**From:** [Chris Cruse](#)  
**To:** [Jeremiah Cromie](#)  
**Subject:** FW: SP-23-00003 Comments  
**Date:** Wednesday, July 5, 2023 7:58:40 AM  
**Attachments:** [SP-23-00003 Map Update.pdf](#)

**From:** Chris Cruse  
**Sent:** Wednesday, July 05, 2023 7:56 AM  
**To:** Jeremy Johnston <[jeremy.johnston@co.kittitas.wa.us](mailto:jeremy.johnston@co.kittitas.wa.us)>  
**Cc:** Hauglum, Paul <[paul.hauglum@skanska.com](mailto:paul.hauglum@skanska.com)>  
**Subject:** SP-23-00003 Comments

HAUGLUM SHORT PLAT PART OF SECTION 34, T. 20 N., R. 15 E., W.M. KITITAS COUNTY, WASHINGTON

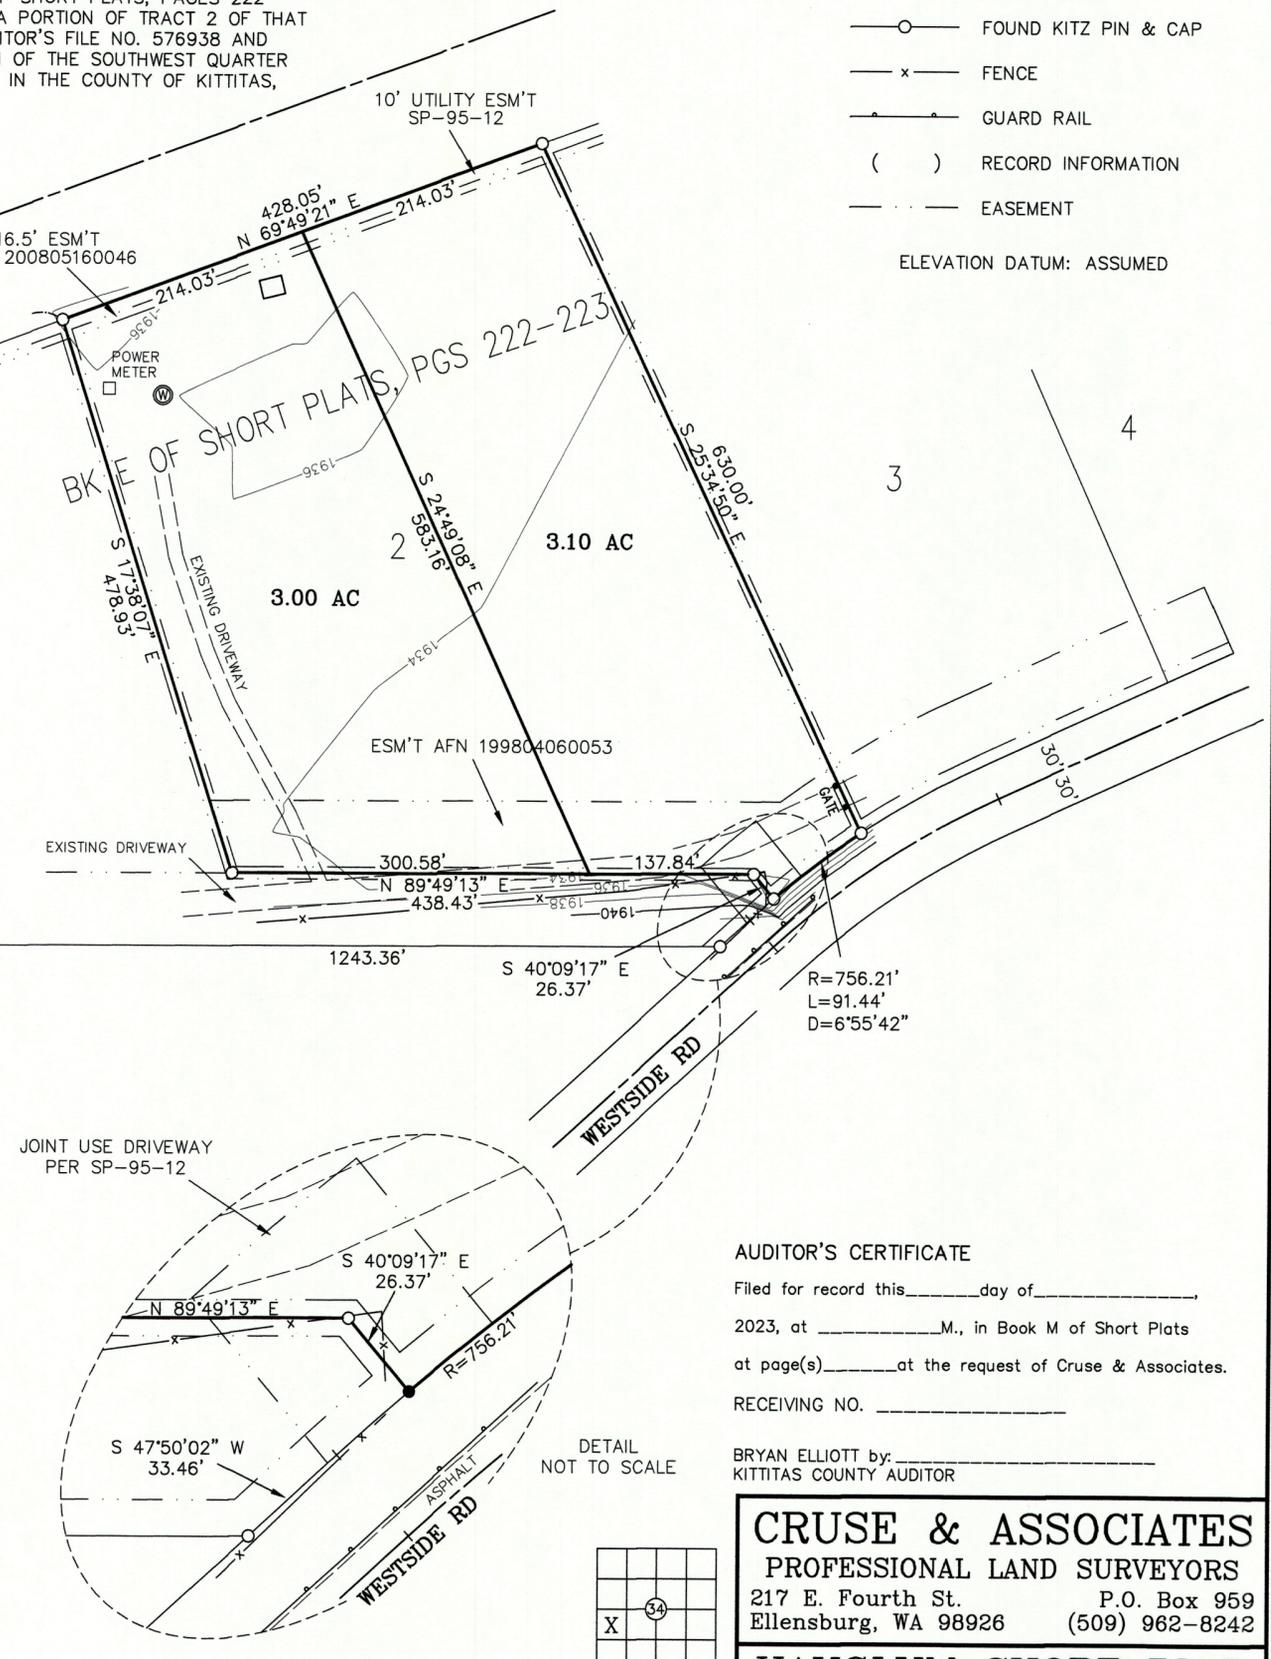
PW commented about missing structures and the map shows the one existing 10' by 16' shed onsite. There is a camper and storage container onsite but are not permanent structures and not included on the map. Also attached an updated map with contour notes to address WAC 332-130-145.
